Our Ref: LU/118/14/PL

**Town & Country Planning Act 1990 (as amended)
Town and Country Planning (Development Management Procedure) (England) Order 2010 (as amended)
Application for Planning Permission**

Development Change of use & extension of part of former office building to a G P Practice with associated parking, landscaping & highway works.

Location Former Bodyshop Offices Courtwick Lane, Littlehampton,

client	Community Solutions	Coastal West Sussex CCG
project	New GP Surgery, Uththampton	East Wing 'Enterprise Hub'
file	Site Plan - proposed	
date	Feb 2014	1:200
scale	paper	drawn
checked	A1	SVR
33157	06	F

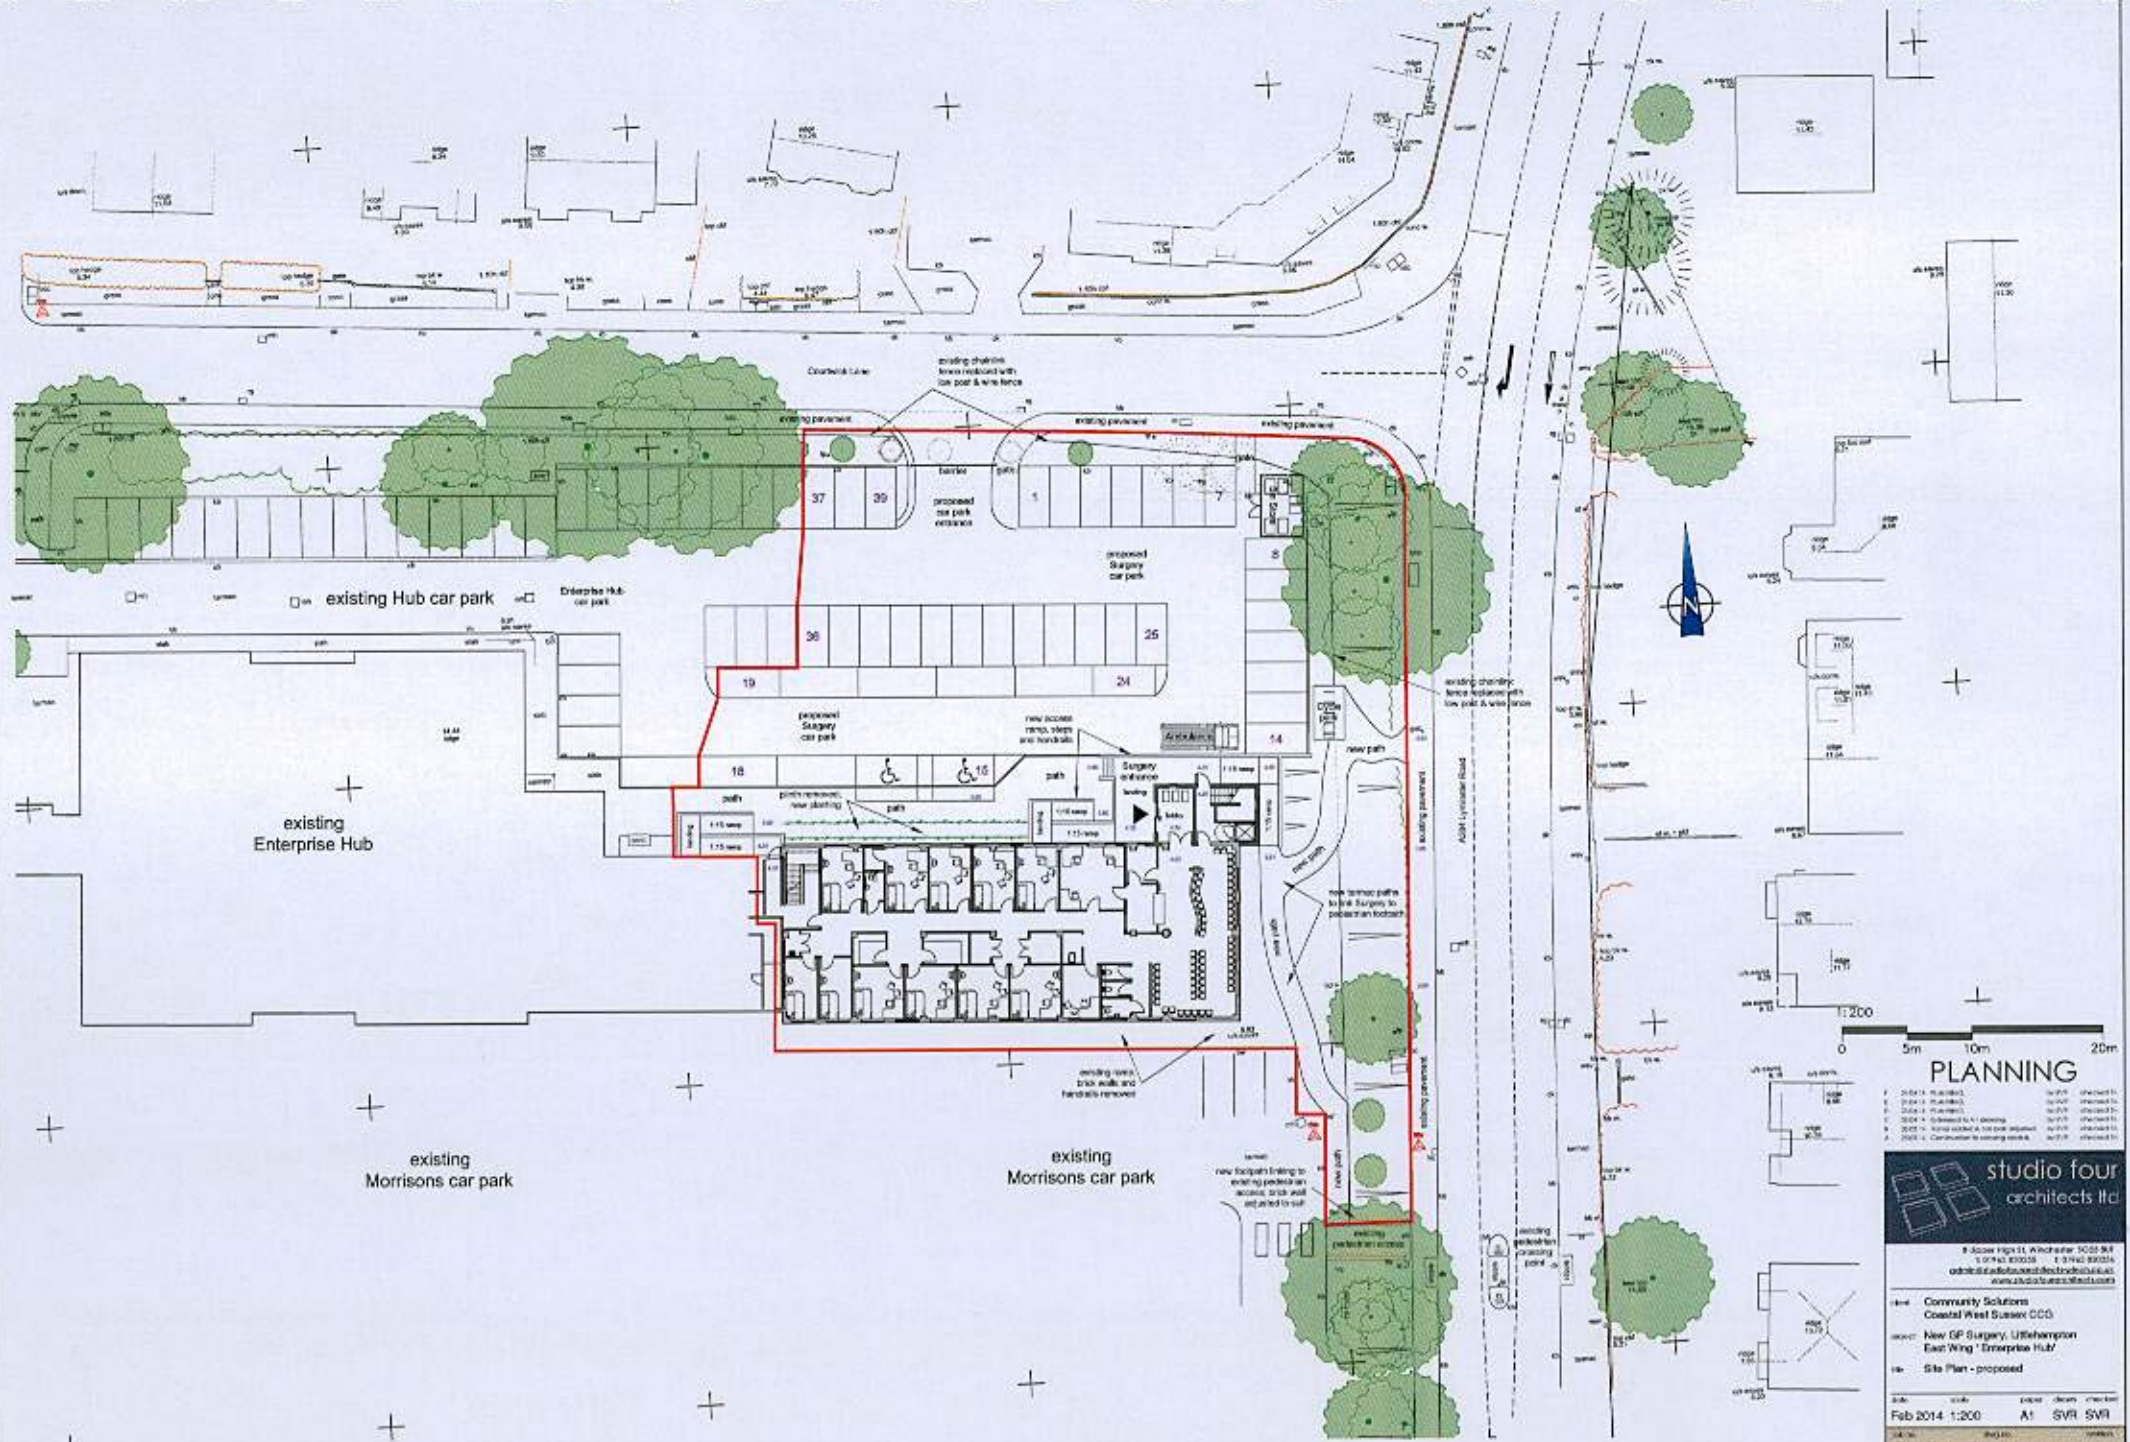
Please provide 1 electronic or 3 paper copies of a revised Proposed Site plan with the site dimensions from the extension to the site boundaries clearly indicated.
